FW: AB/142/25/HH - 59 Tarrant Street - SUB PLAN

Please upload the attached sub plan as REV A for AB/142/25/HH

It should replace: Ground Floor Plans - Existing and Proposed 02 (ID 13)

Drawing file: AB_142_25_HH / TS 02 Ground Floor Plan - Existing and Proposed.pdf

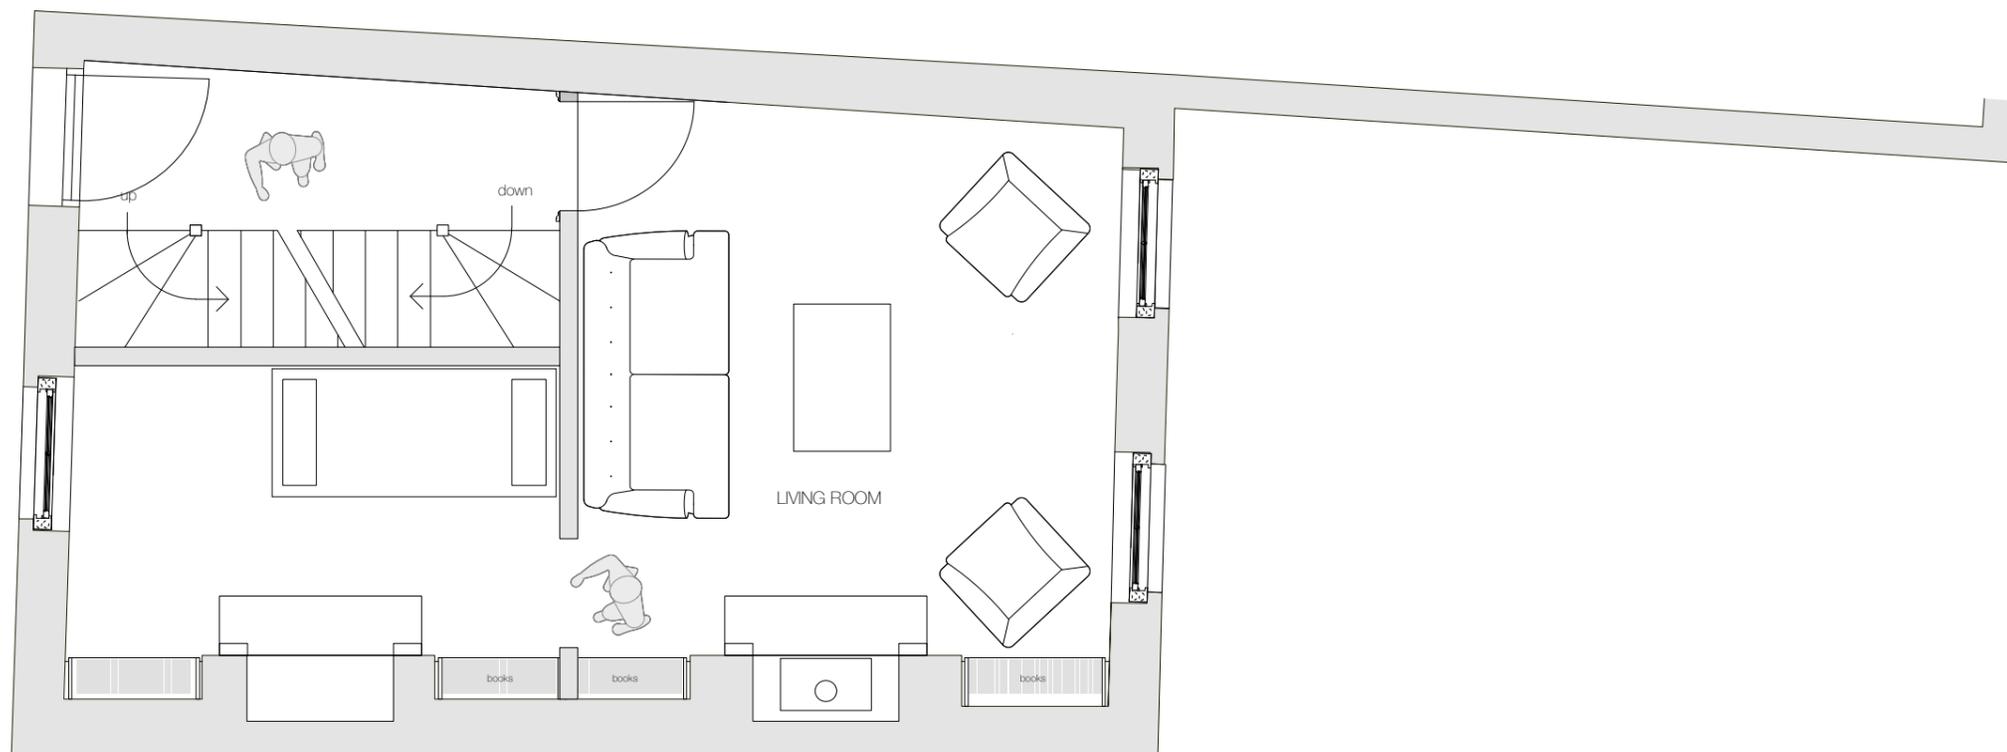
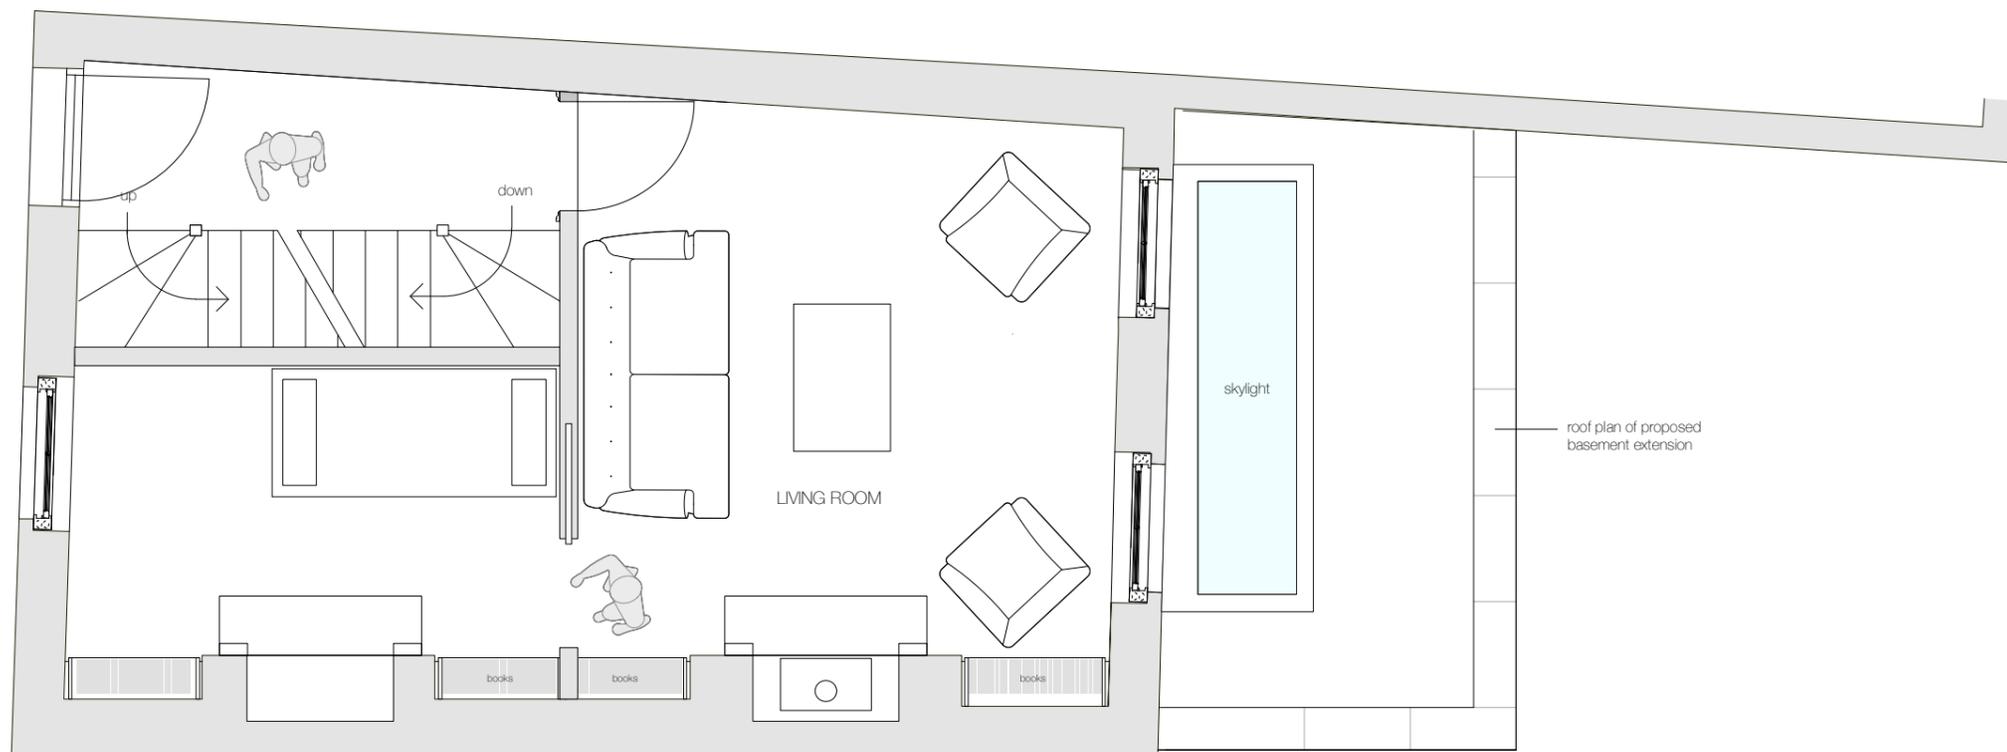
Please find attached drawing TS 02 which shows the roof plan of the proposed basement extension. I realise I'd shown the roof of the existing extension on the ground floor plan, so hopefully this is the modification you need. Sorry for the confusion. Roof plan is replicated on TS 05.

I am the case officer for the above application.
It appears that the floor plans do not show the extension proposed. Please could you amend the plans.
